From: [REDACTED]
Sent: [REDACTED]
To: Sian Eggington
Subject: FW: Request for further information EP/86/20/HH
Attachments: Planning 6 Golden Avenue.pdf; We sent you safe versions of your files

Front Elevation - East

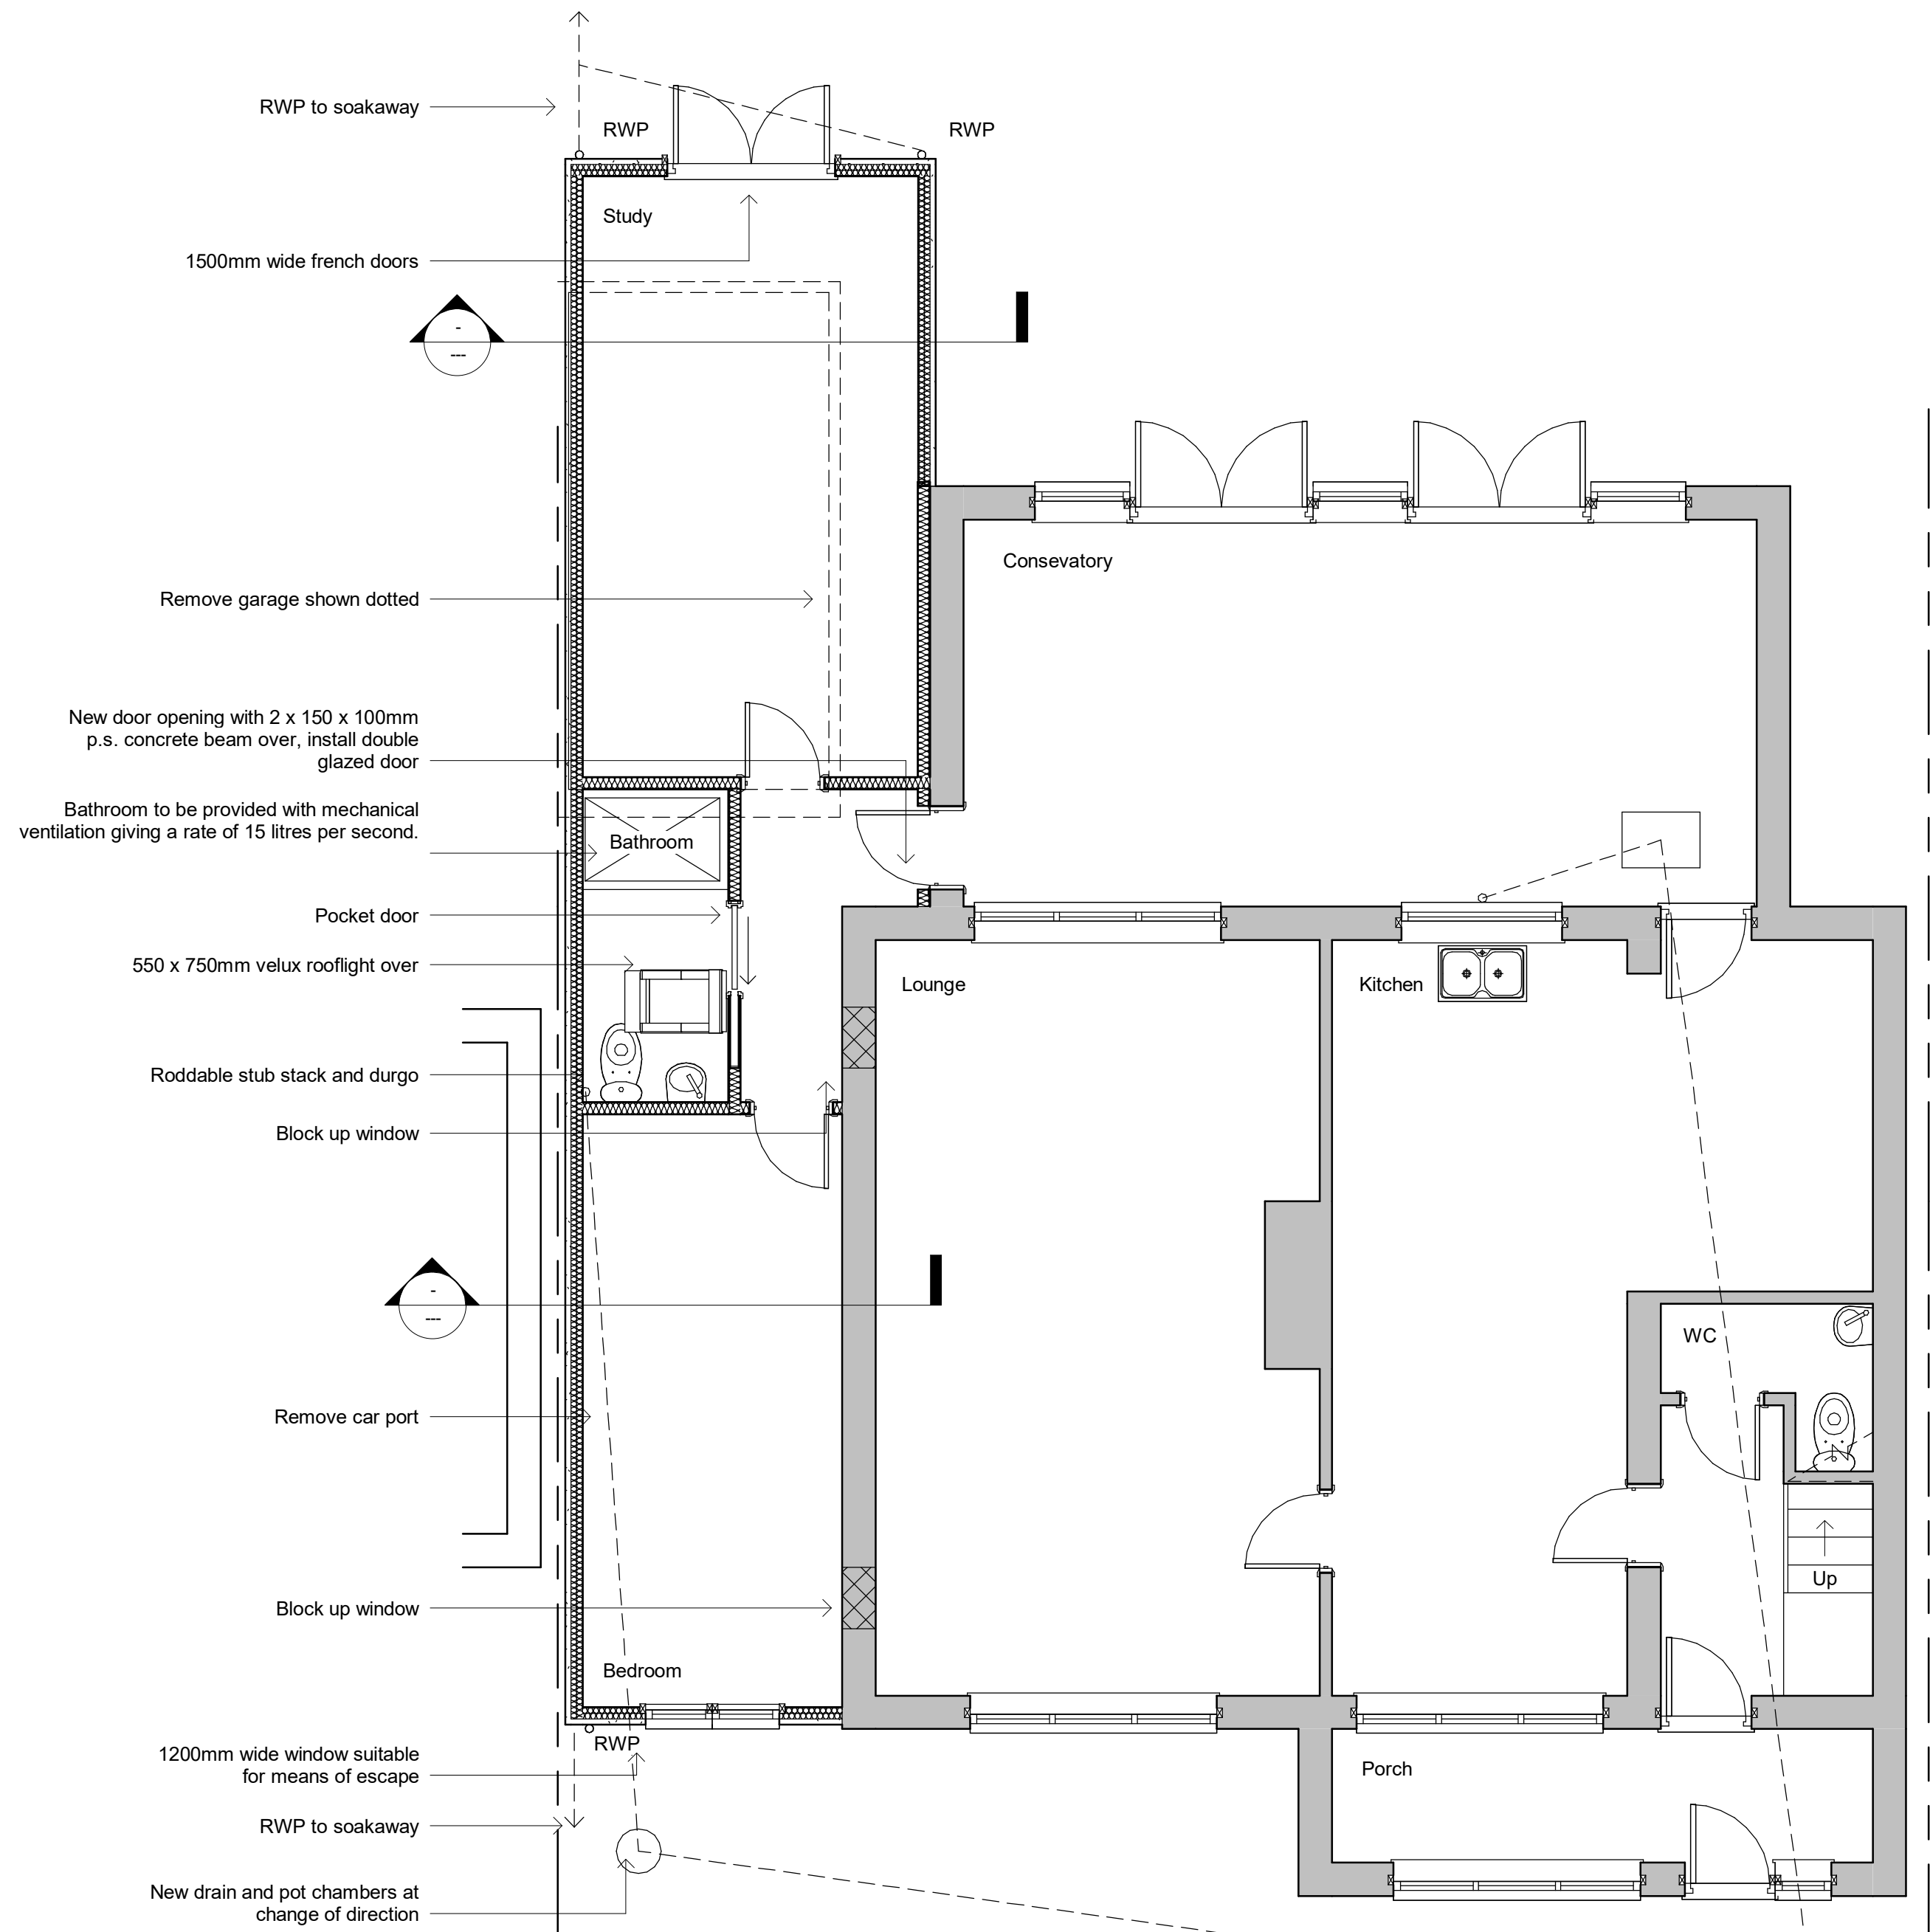
Unfortunately your application is still invalid as the front elevation building line is inconsistent with the floor plan. Please amend.

Im sorry but the the floor plans and elevations are correct. if you are referring to the line it just highlights the new work.

Revised drawing attached, please finally validate the application.
